Application by Highways England for an Order Granting Development Consent for the A303 Sparkford to Ilchester Dualling project

South Somerset District Council response - in relation to the Unilateral Undertaking submitted in respect of issues of bird strike

2.3 Works Plans

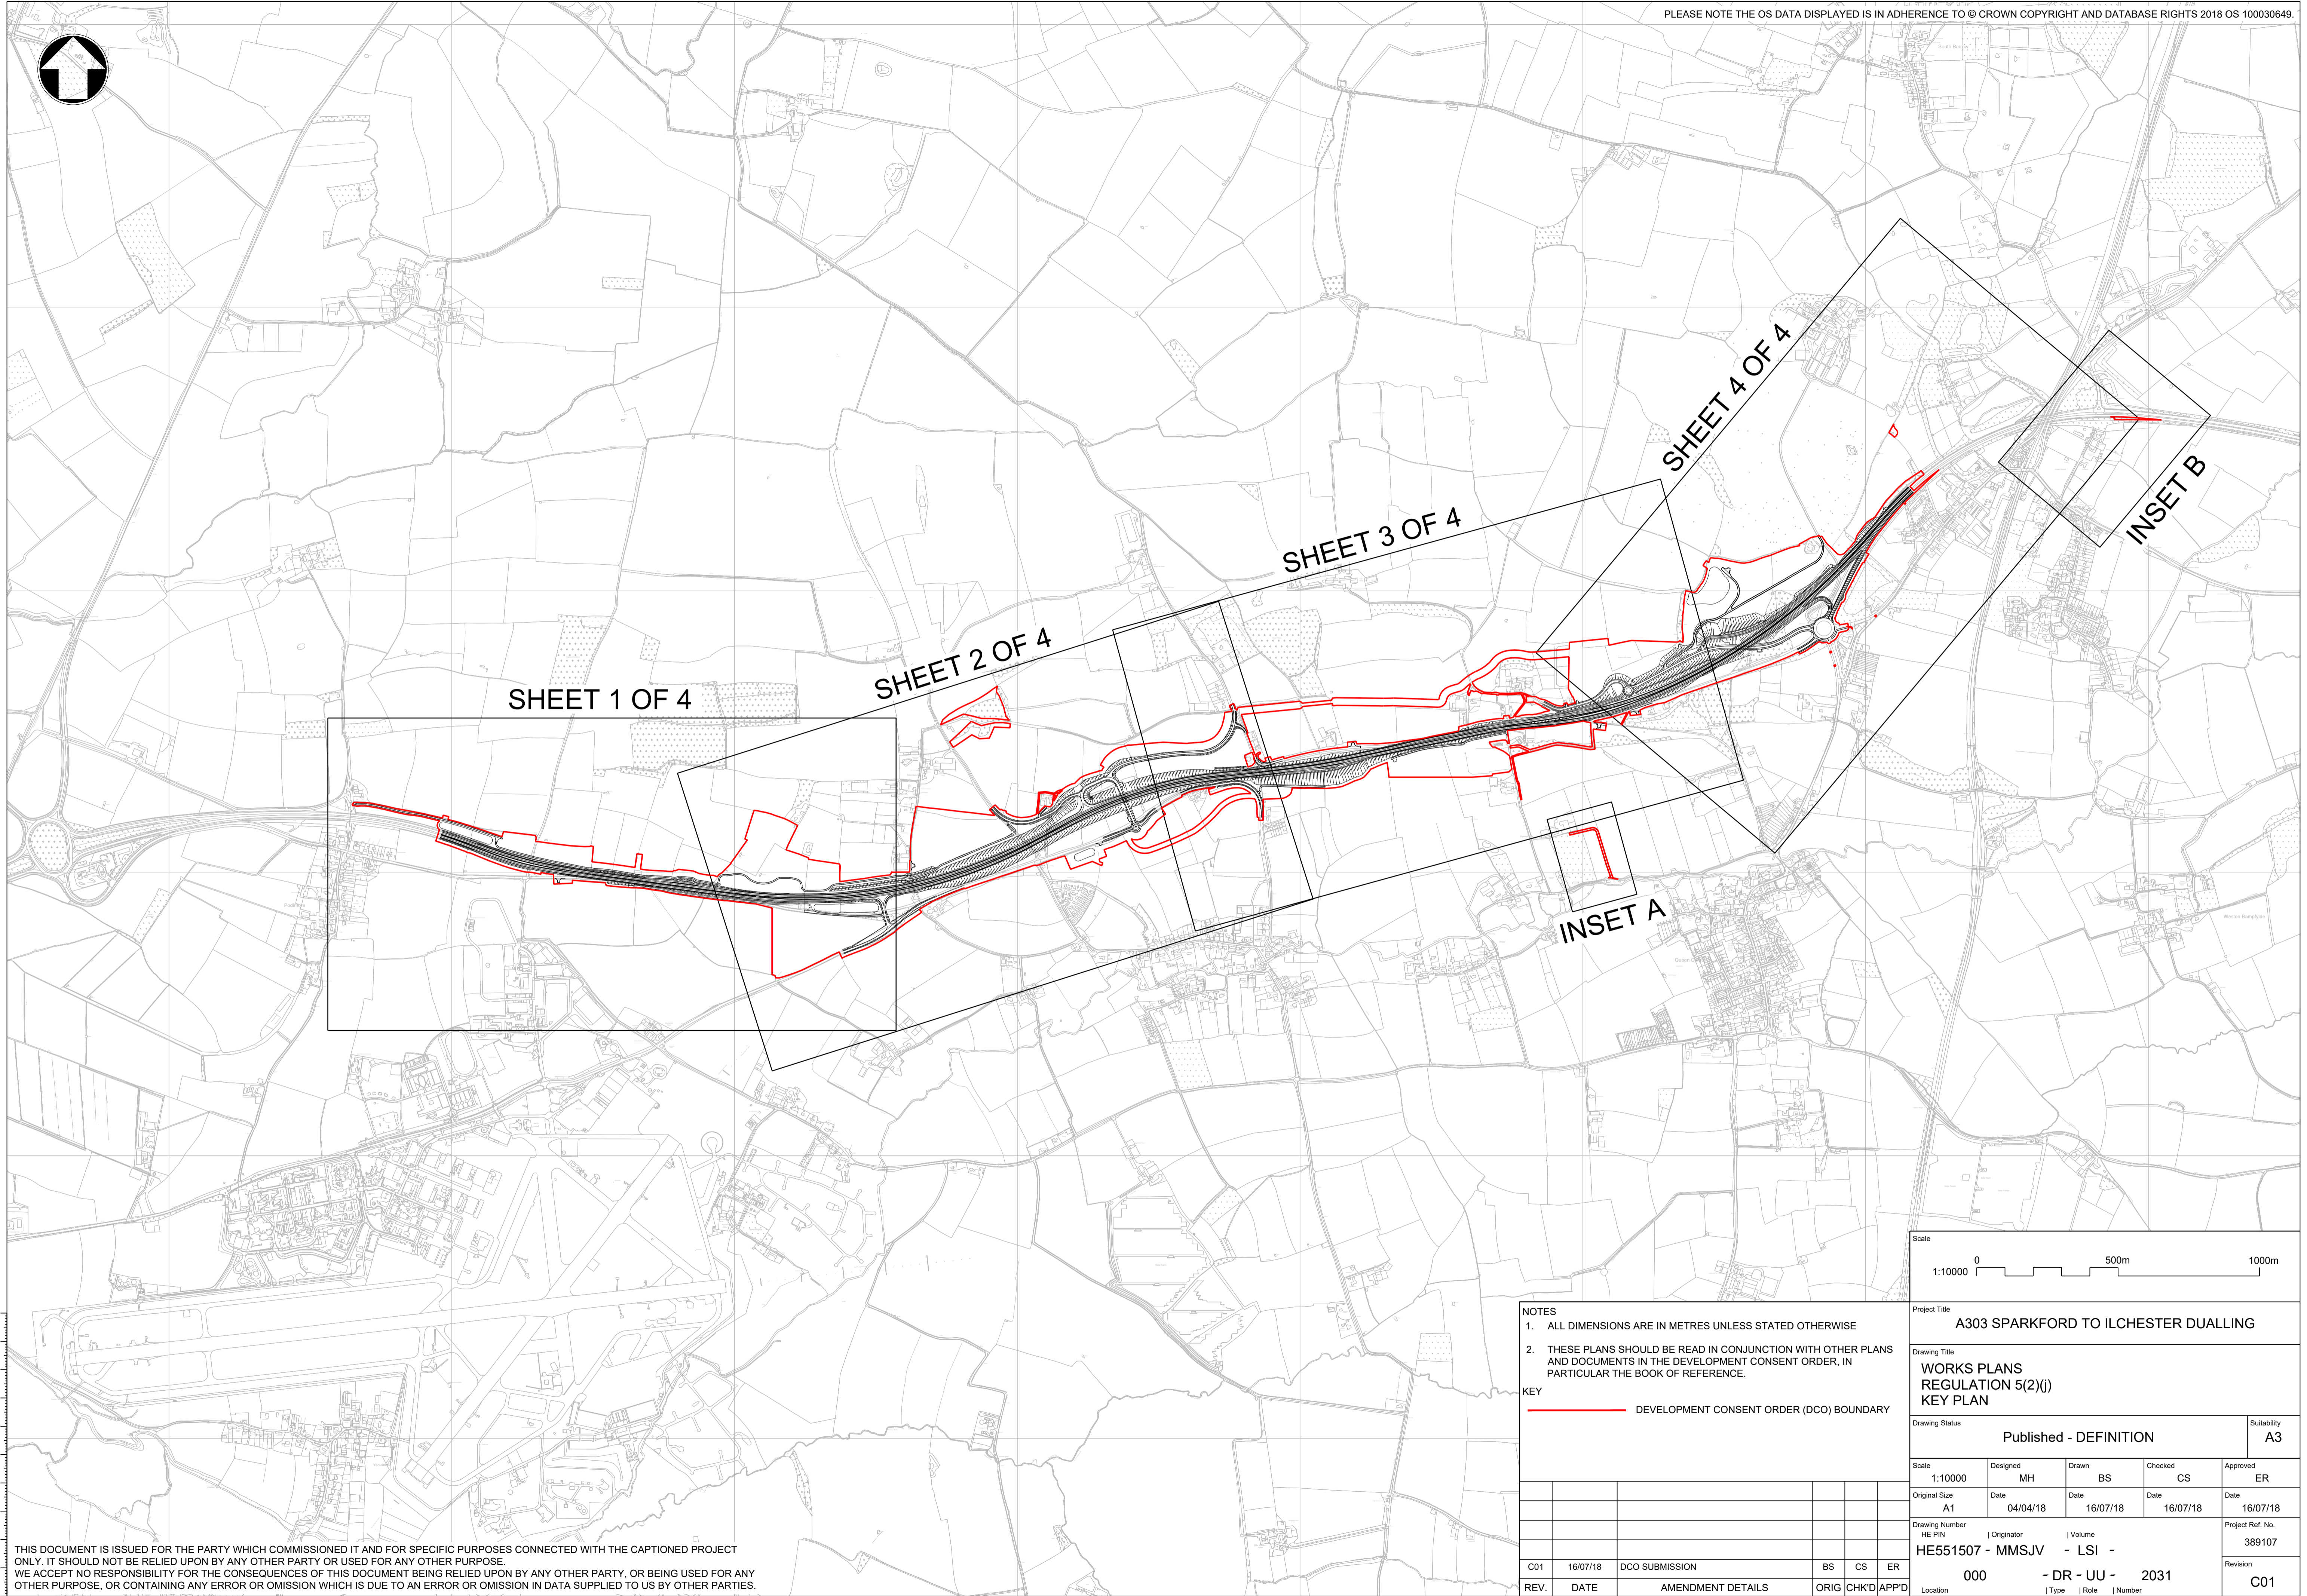
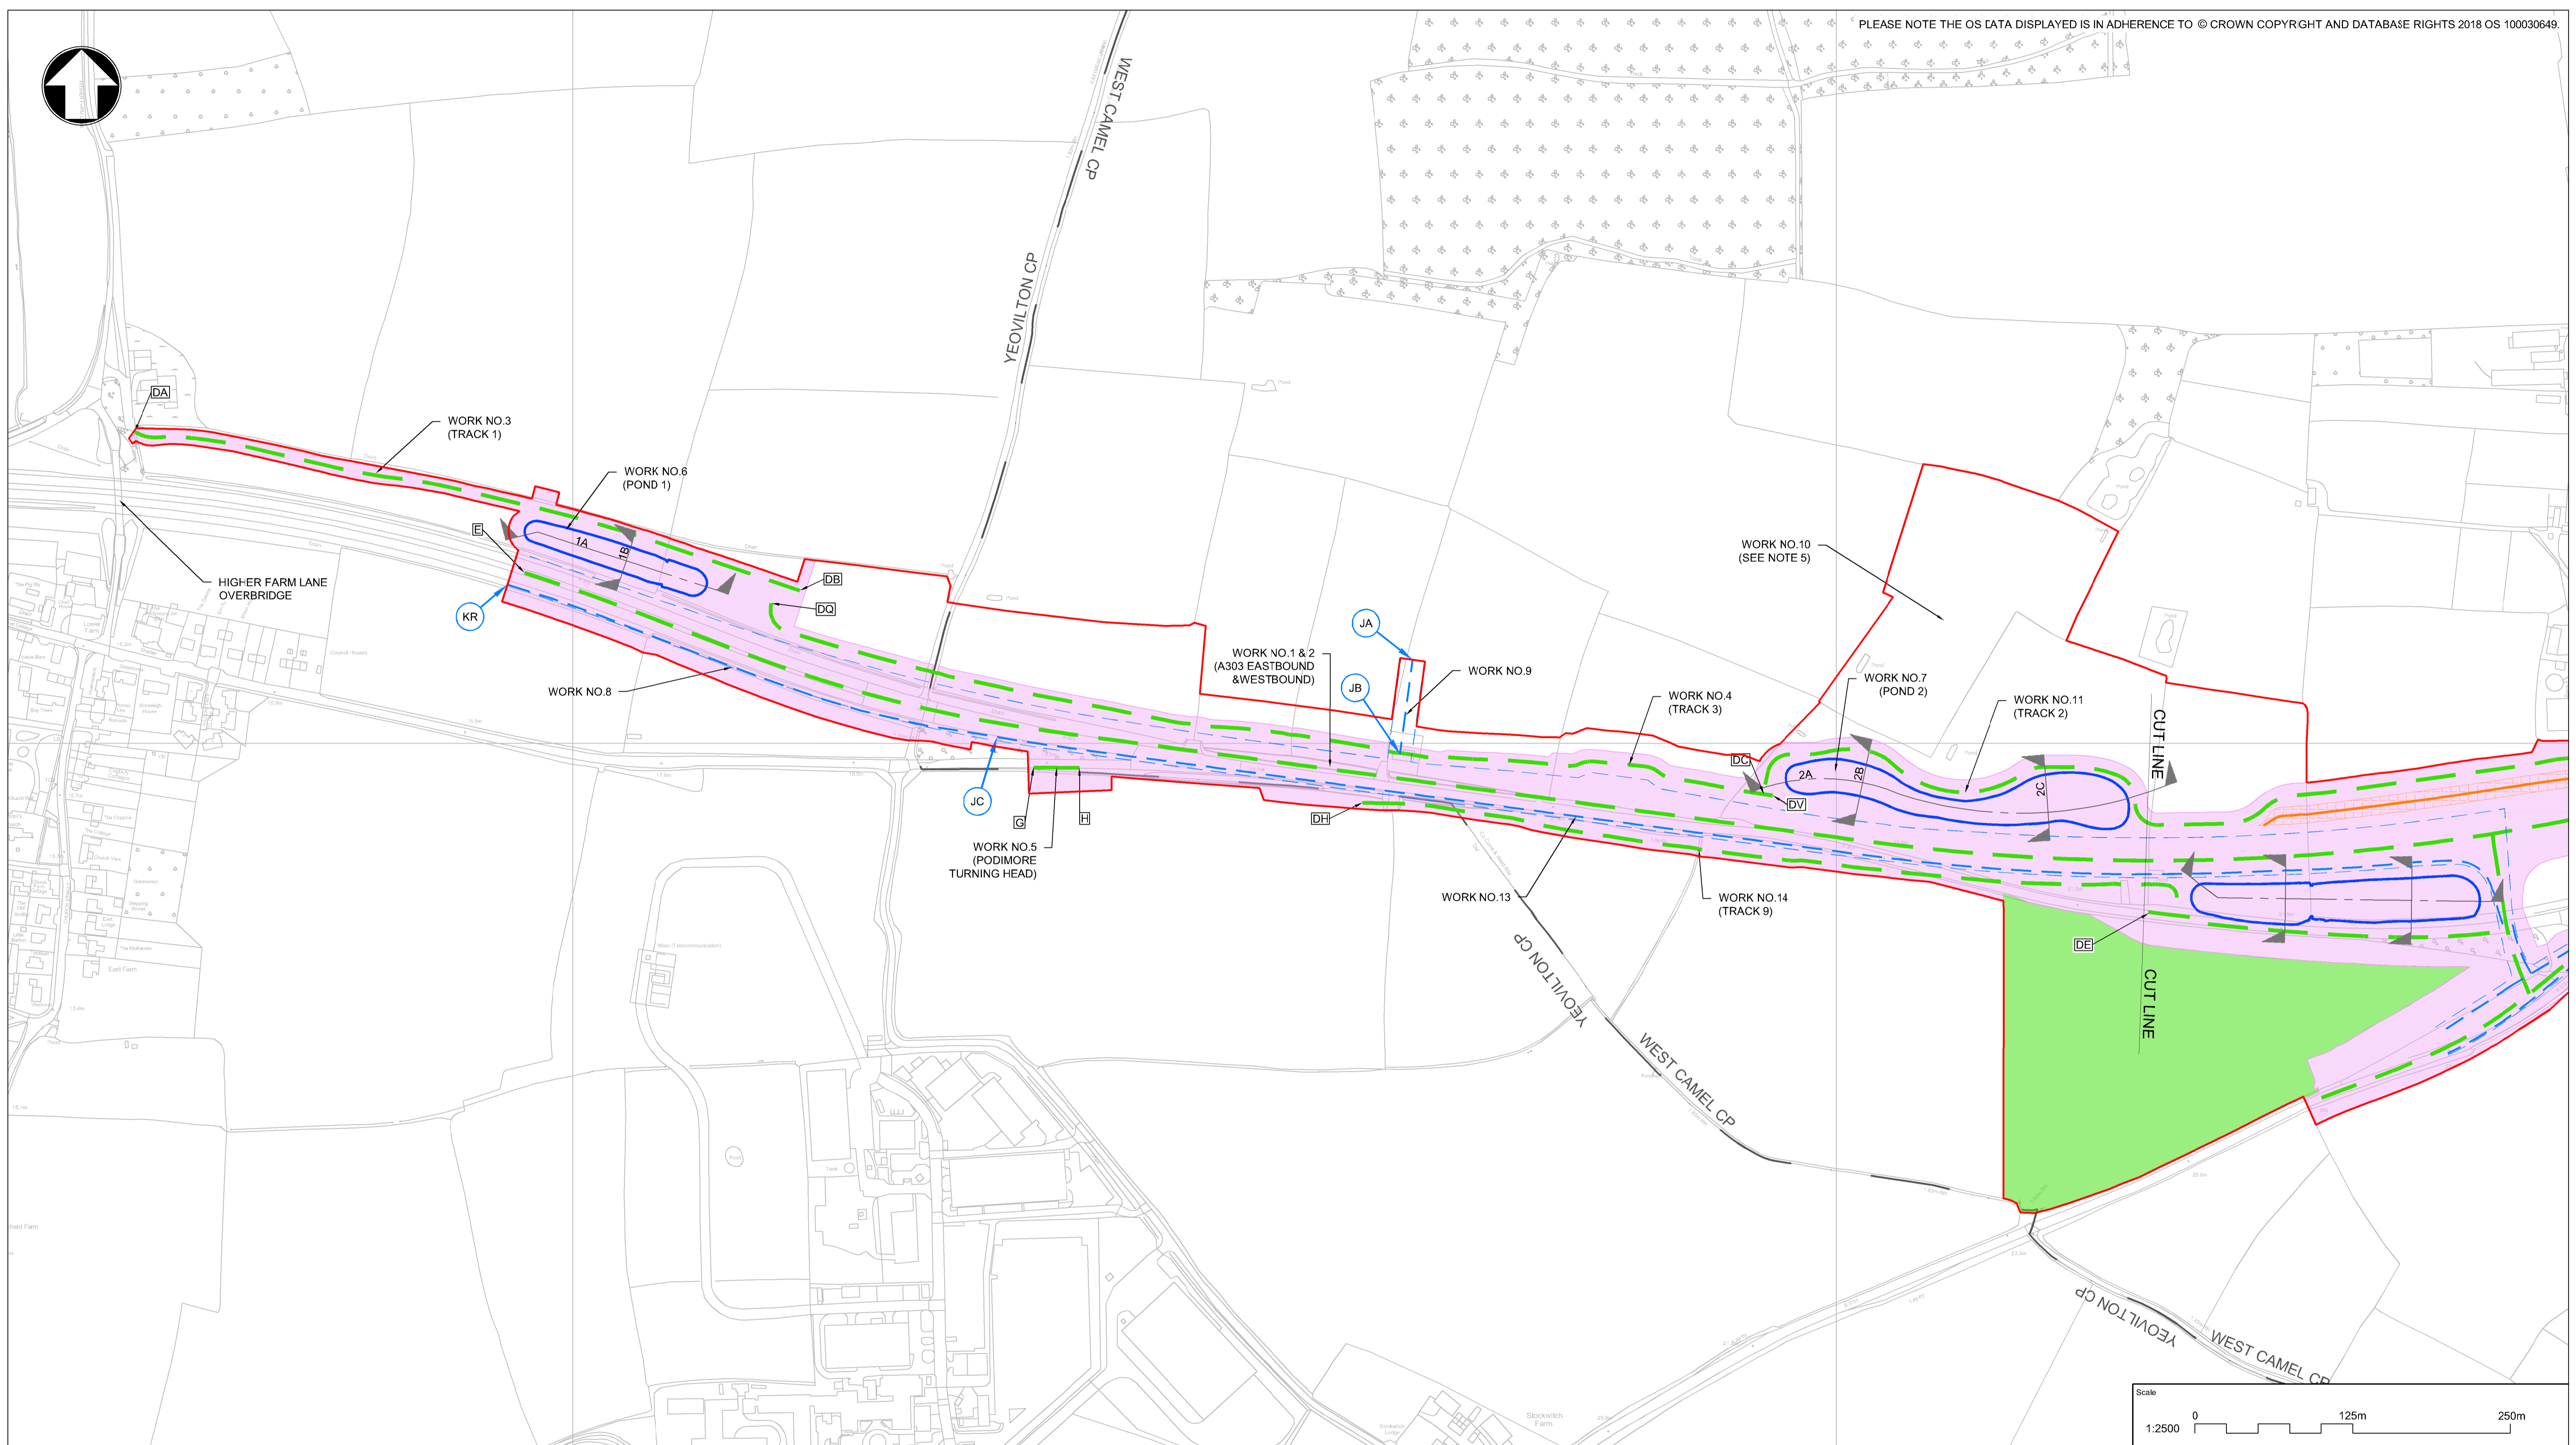
1. For the purposes of clarity, confirmation could be provided on the face of the UU that the Ponds will be within the continuous red line as shown on Plan 1 by amending the definition of the Ponds to refer to its location within the Site.

2. If there is any prospect of the final location of the Ponds will be outside of the continuous red line on Plan 1 (through the detailed design requirements or the process generally) then this must be addressed as it would appear that obligations in the UU may not be enforceable in that scenario.
